## MEMORANDUM

**Subject:** Application ID: 2013-255

**Comments Submitted by: Ann Machado/Zoning on 12/9/2013**

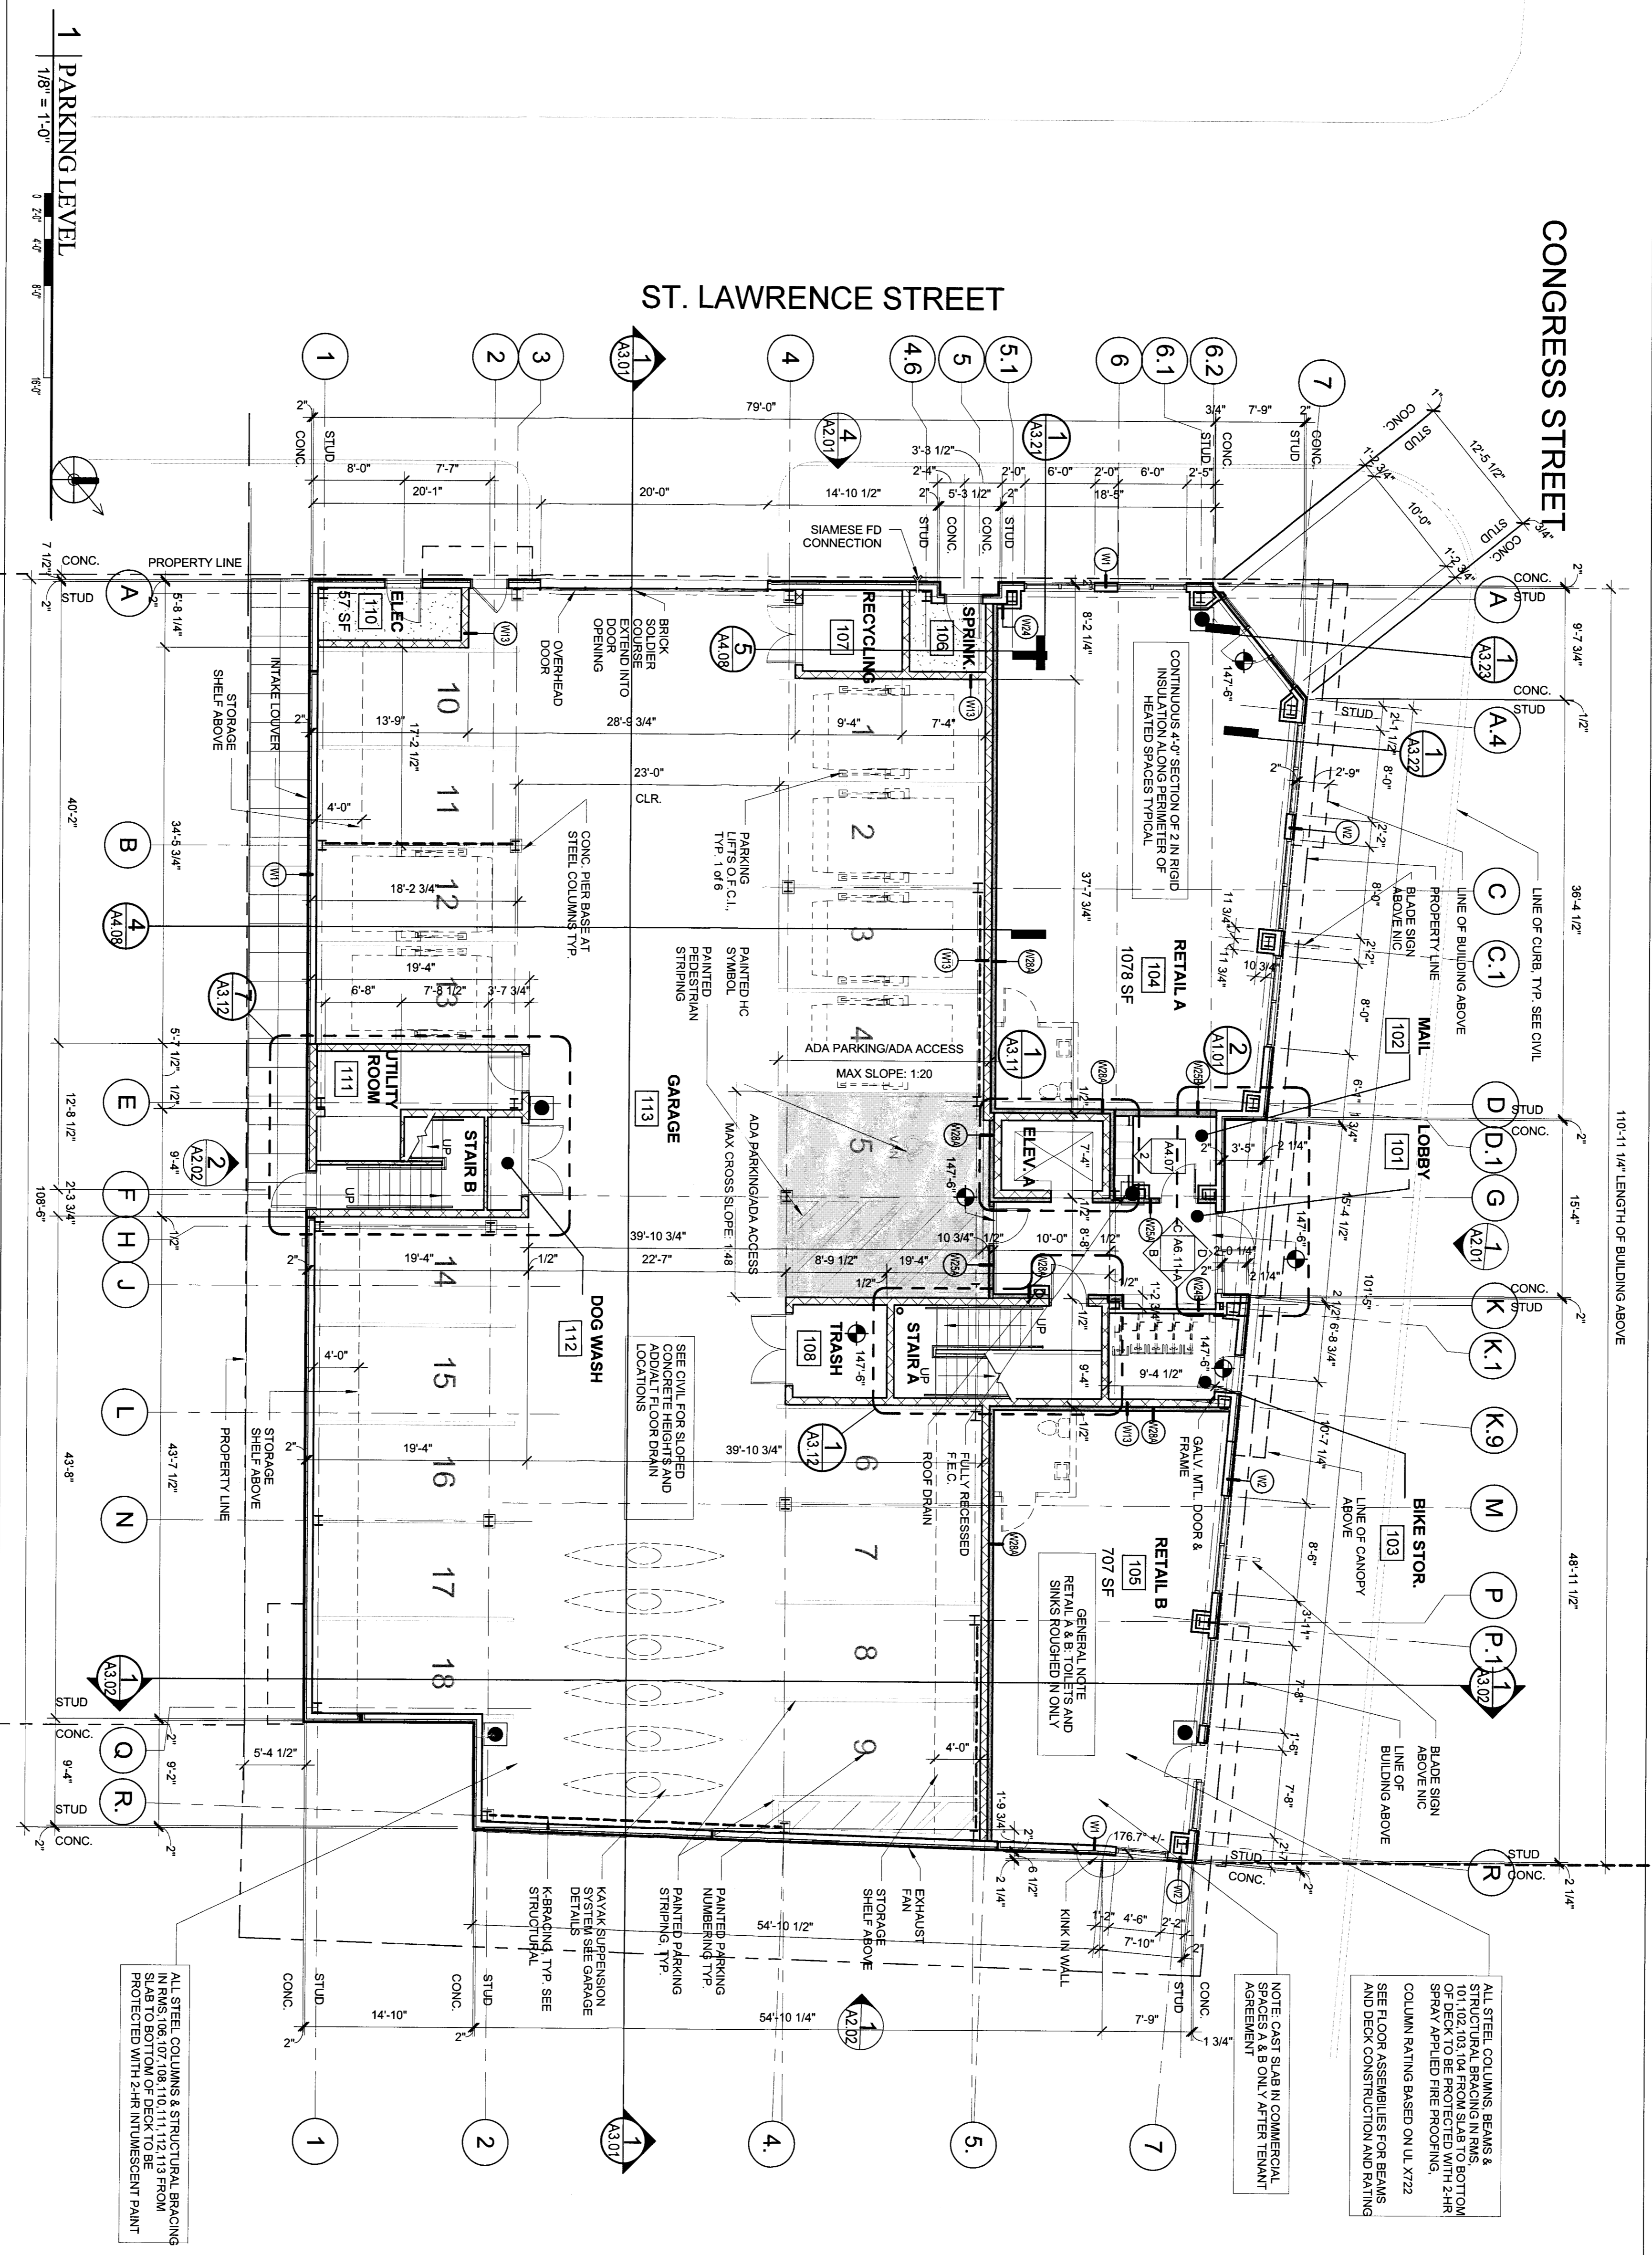
Looked at revised plans submitted 12-6-13. A1.1 shows that the proposed building now meets the 20' rear setback behind 25 Monument Street. The overall footprint of the structure has been reduced to 8,981 sf. Parking spaces 15-18 have been reduced to 8.5" by 18'. A1.02 shows that the length of the deck & enclosed glass bumpout has been reduced to 19.5'. on the western elevation towards the rear of the building. The enclosed (glass) living areas and the decks on floors two through four still encroach 2.5' over the property line on the west and north sides of the building and still extend 3' off the principal structure.. The two blade signs shown on A1.01 are not being approved at this time.
